From:
Sent: 19 January 2025 14:08
To: DC Admin
Subject: Application Number 2024/93556

I am objecting to this planning application and have the following comments to make regarding it.

Existing Site Plan
(1:500)

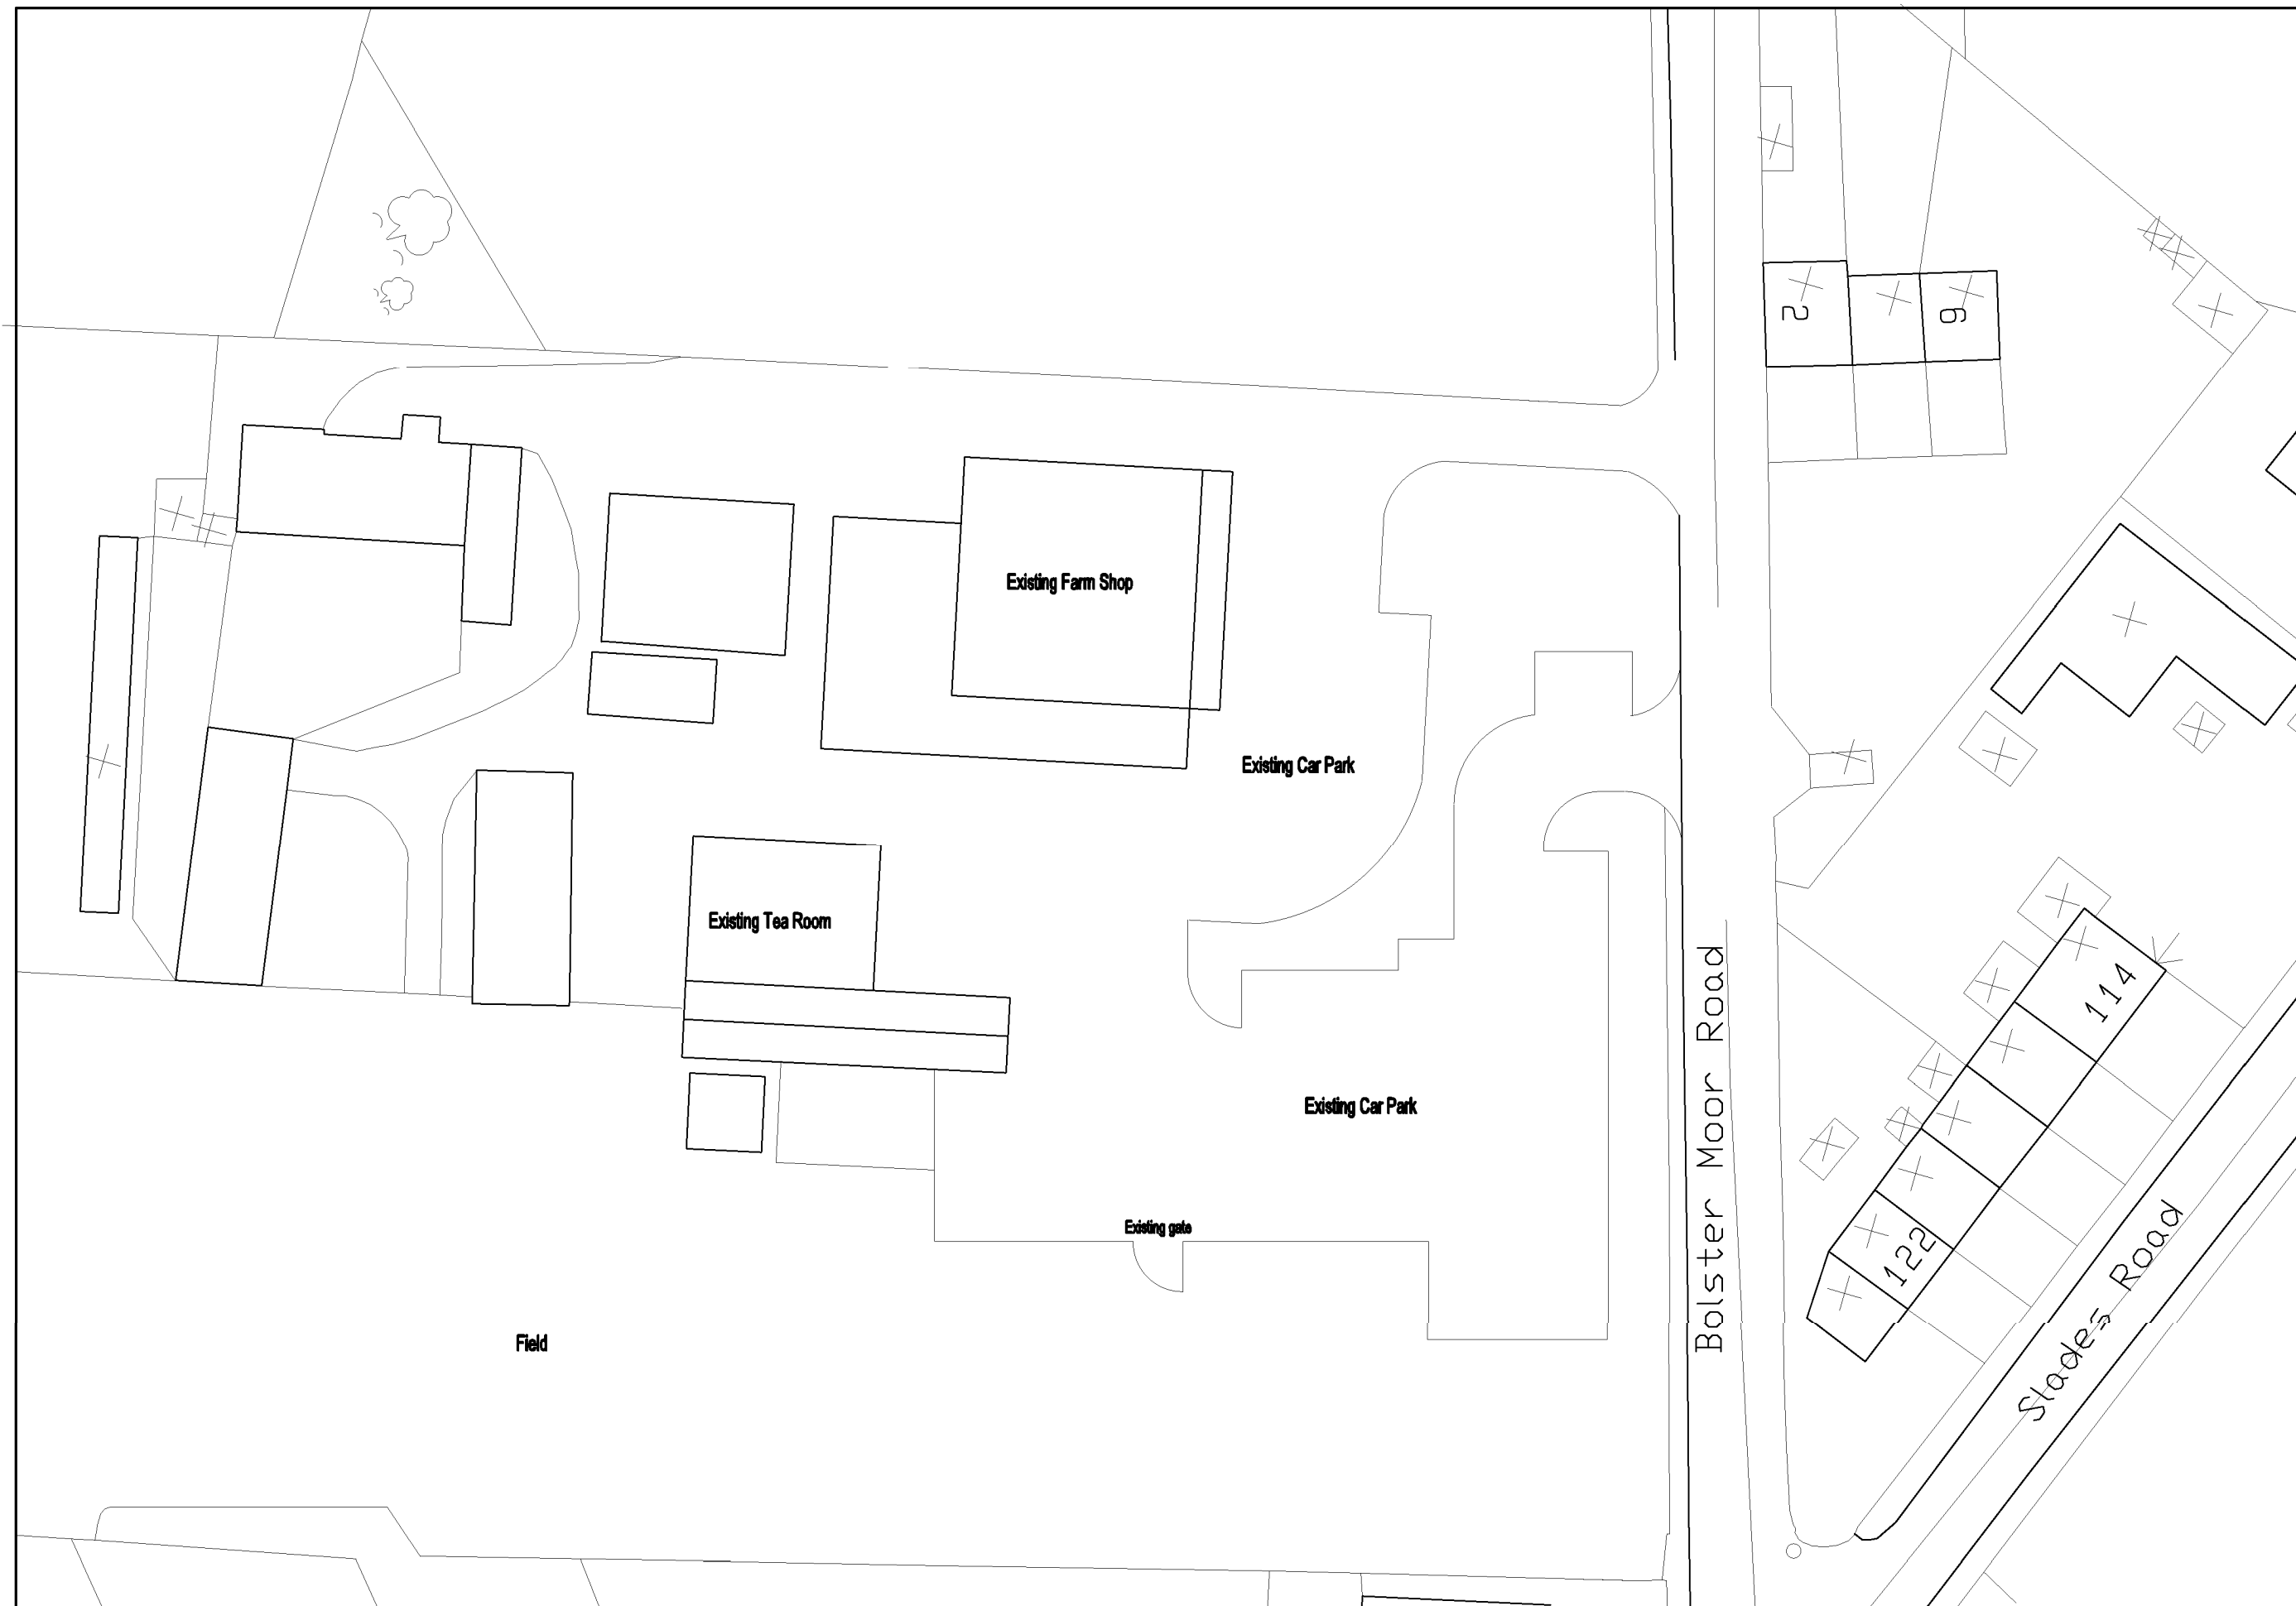
On 19 September 2024 work was carried out to extend the area of parking beyond the 22 temporary spaces allowed in the Certificate with a new entrance to this area being created by removing part of the landscaping and fence in the lower part of the permanent car park and an artificial hard surface being installed and marked with permanent car parking spaces – all completed without the relevant planning permission being sought. This work directly contravened the conditions imposed by the original Certificate. This area of land is in a designated Green Belt area.

Point 3.9 states that “the proposed development comprises a flat car park”. This is incorrect as the area of Green Belt land in question is sloped. This means that cars parked higher up the slope can clearly be seen from the roadside, thereby having a detrimental impact on the openness of the Green Belt. Moreover this sloping man-made surface is likely to add to drainage problems.
